The objections within the application 2020/62/91049/W that was withdrawn, still apply within the application 2023/62/91327/W.

PROPOSED SITE PLAN

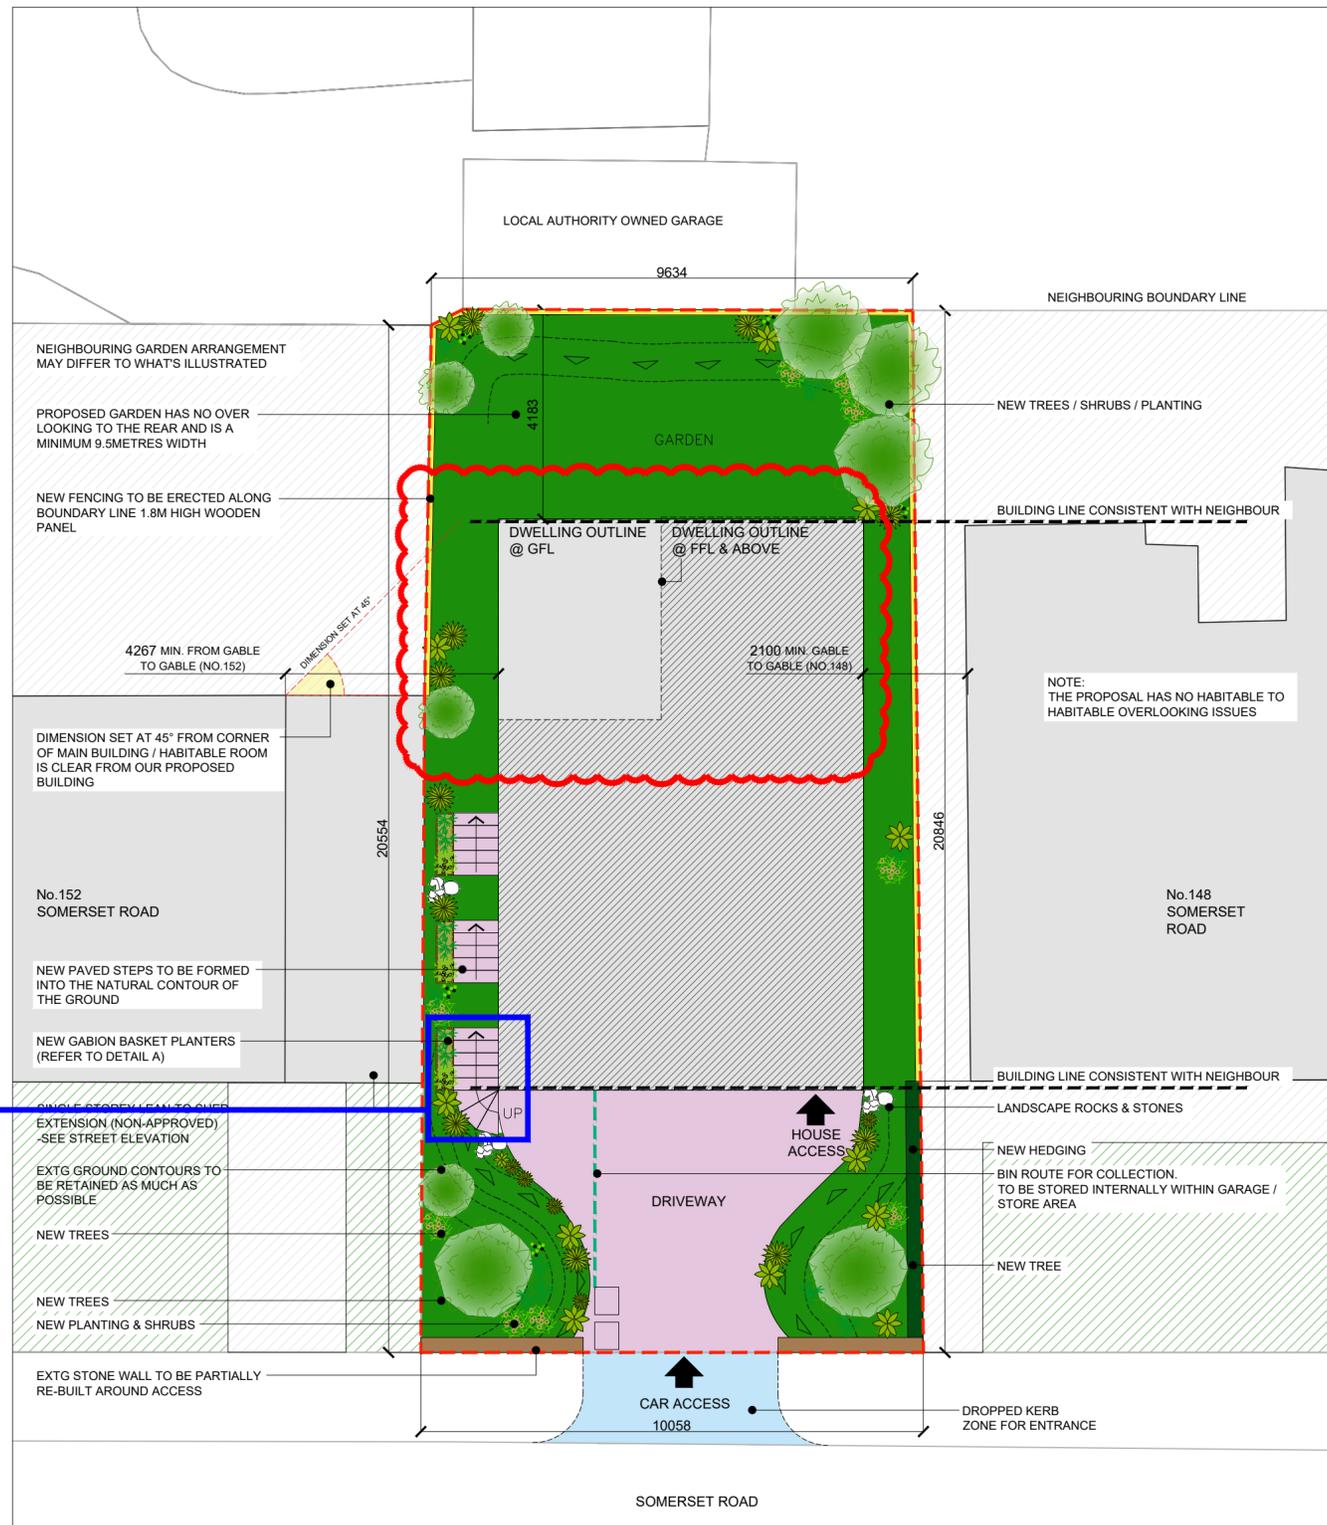
Noted, within the garden tenancy agreement for the neighbouring property, access is always required for Kirklees Council and British Telecom officials, which the current proposal does not demonstrate any pathway to allow such. Instead, the landowner proposes to imminently fence off the entirety of the area where a current pathway is observed.

Additionally, to this, the plan exceeds the actual boundary of the proposed land so initially before any agreement can be made, this needs to be rectified in the plans to accommodate this.

The current proposal does not disclose what material the boundary wall will be replaced with but consultation of this has not been discussed with the affected neighbours.

Currently there is a wall that has been affected by subsidence due to the premature work on the proposed land. The applicant proposes to fence the entire boundary, which due to the other plans of replacing the greenery and trees, this will in turn mean the maintenance of a fence from the future residents within the proposed land will not have sufficient access to do this.

DRAWING:
PROPOSED ELEVATIONS

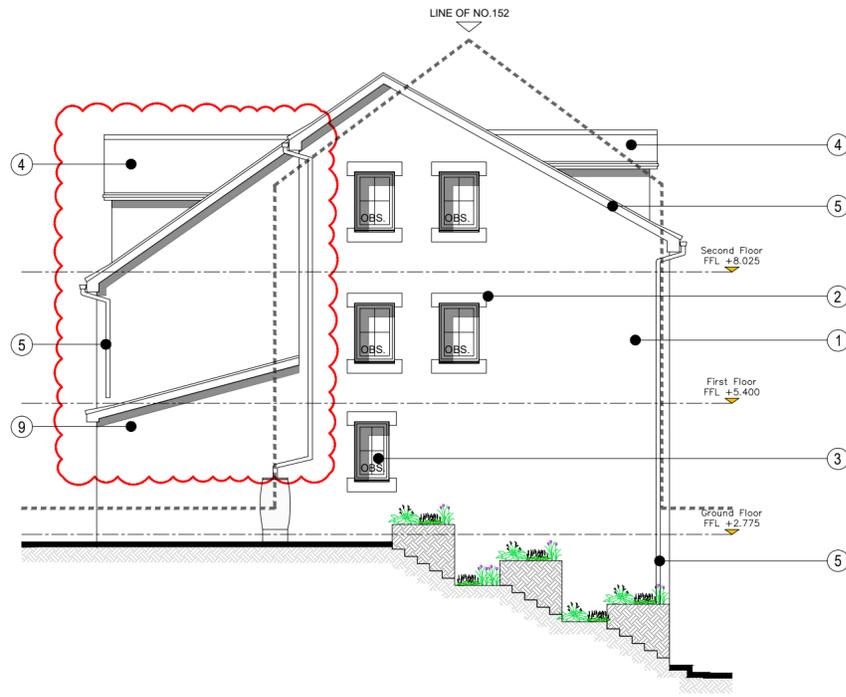
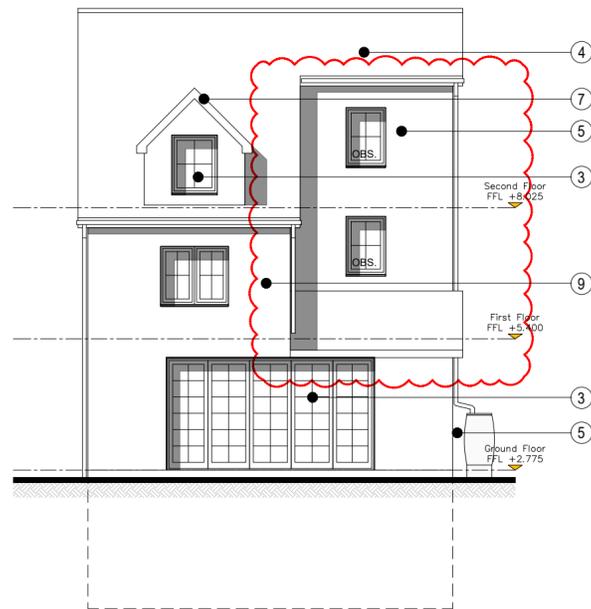
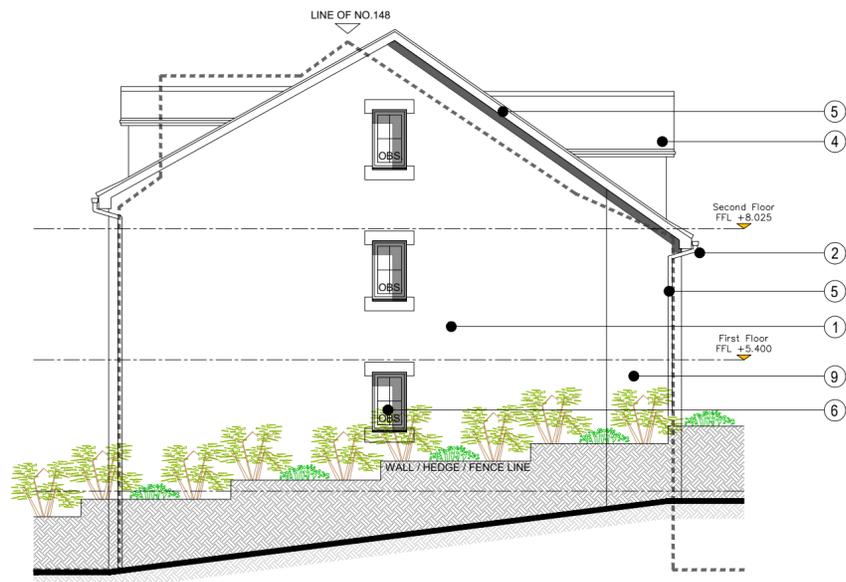
The revised plans now show 5 windows and another 3 windows on the sides of the proposed property.

This is an invasion of privacy to both neighbours, with young children residing.

This area of Somerset Road is of Victorian heritage and still no attempt has been made to design a dwelling that complements the current buildings on Somerset Road. This potential dwelling will stand out from the rest and take away from the current beauty and appeal of the area, especially the proposed 'white render'. Given the surroundings, unless maintained this will lead to quick discolouration therefore bringing less appeal to the area and lowering standards and result in incongruous features that would be out of keeping with adjacent properties and street scene.

The proposal of such a development would be detrimental to the predominant character of the townscape and visual amenity of the area failing to accord with Policy LP24 of the Kirklees Local Plan and Policies.

PROPOSED
LOWER GROUND FLOOR PLAN

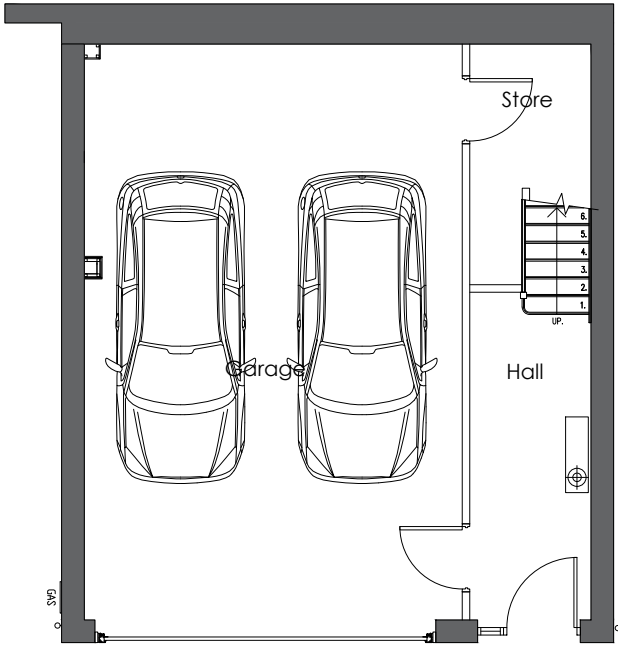
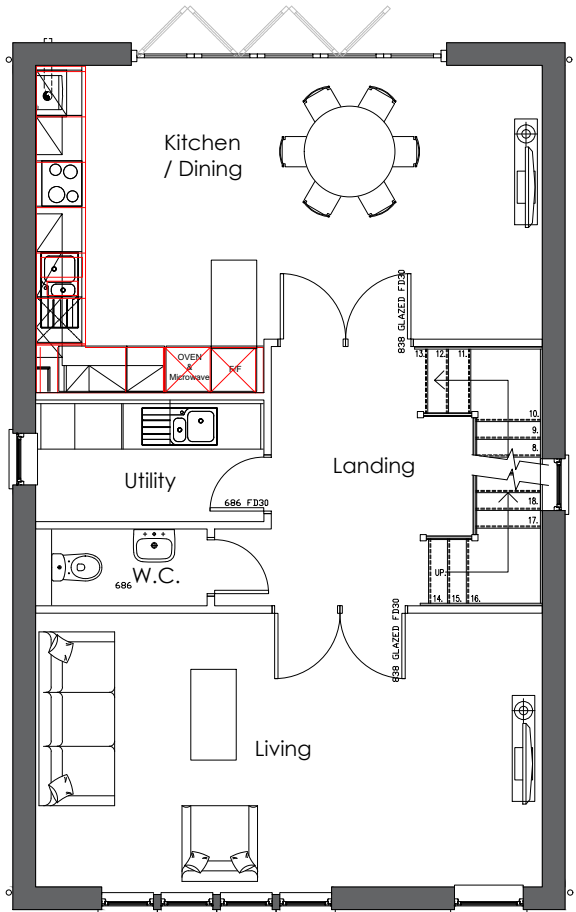
The plans again suggest a sub level basement garage that has the capacity for two cars, which is not viable. Parking is already at a premium when it comes to Somerset Road and this dwelling will take away potentially three parking spaces from an area that is currently over subscribed for access to this garage.

The highway grounds of the objection from the previous application still stand, the proposal of the garage takes away more of the premium spaces that there currently are and is no guarantee they will utilise the space as designed and take even more demand away from current residents causing inconvenience and tension amongst all.
